ADC PARKS & GREENSPACE ARBORICULTURE

PLANNING APPLICATION: AL/45/14/PL

ADDRESS: Land rear of Swan Court, Pine Close, Westergate, PO20 3AE

BRIEF DESCRIPTION: Erection of 3No. Detached dwellings (Plots 1-3 and car port serving plot 4) (Part alternative to AL/69/10 and AL/89/10)

Figure 3: Ground Protection Specification

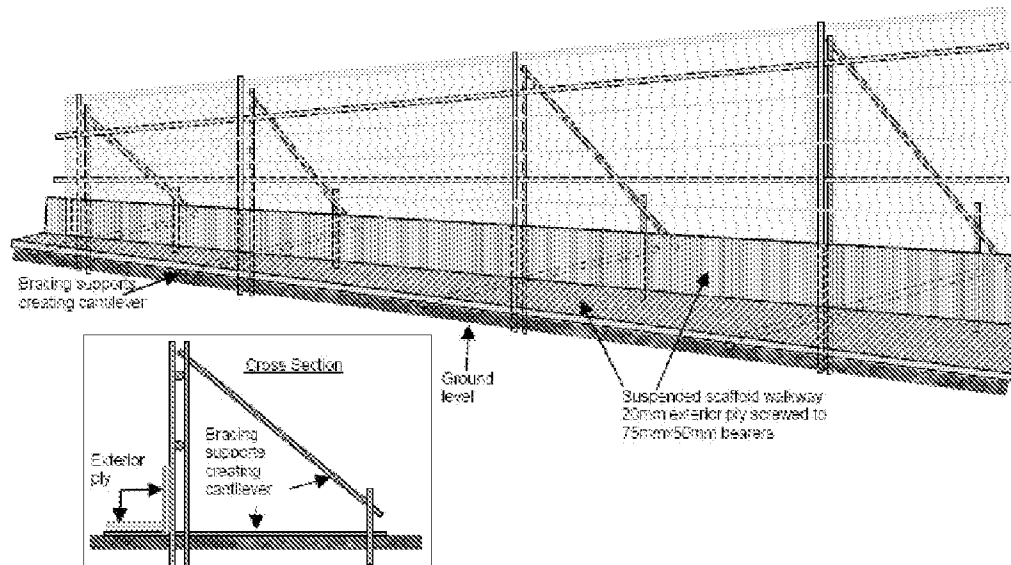
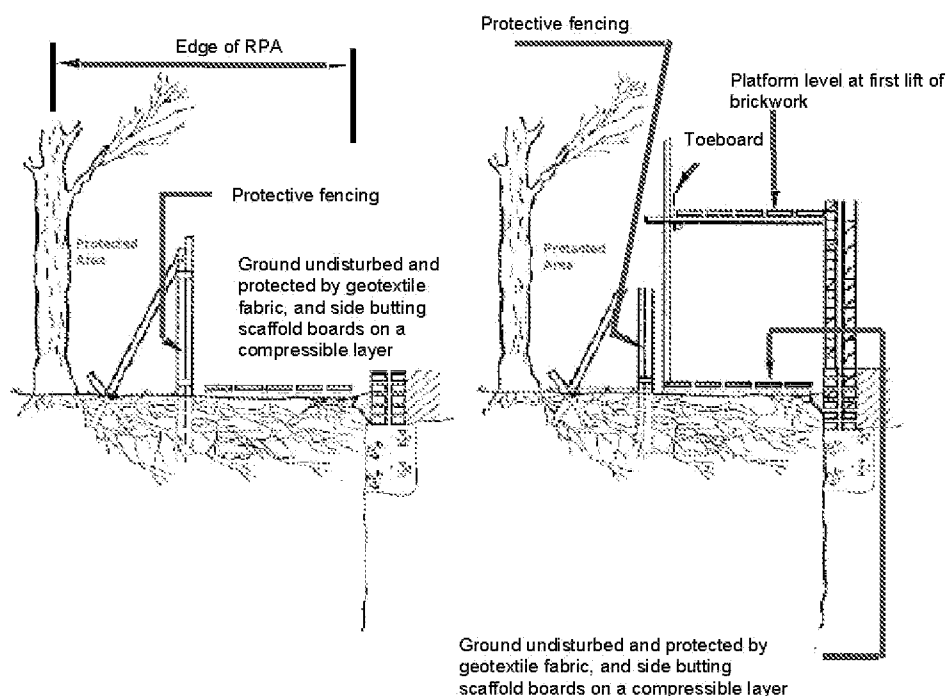
- With this development there is a requirement to work within the Construction Exclusion Zone (CEZ) of trees 1-6. The arboricultural report has correctly identified the appropriate methods for the protective measures that would be used for differing machine (weight). At the time of the arboricultural report was submitted the developer there had been no confirmation of what type of vehicles would be omitted into these areas. This will have to be confirmed prior to the works beging and the correct protective measures implemented.

- I would like to approve this application on a conditional basis. The applicant needs to confirm the following before the process can begin:
 1. Specifying the ground protection that will be used for protection in the CEZ for trees 1 - 6. This **protection must reflect the machinery that will be used on site.**
 2. Implementation of all **protective fencing/membranes at correct distances, and then converted to a static state** for the development process.
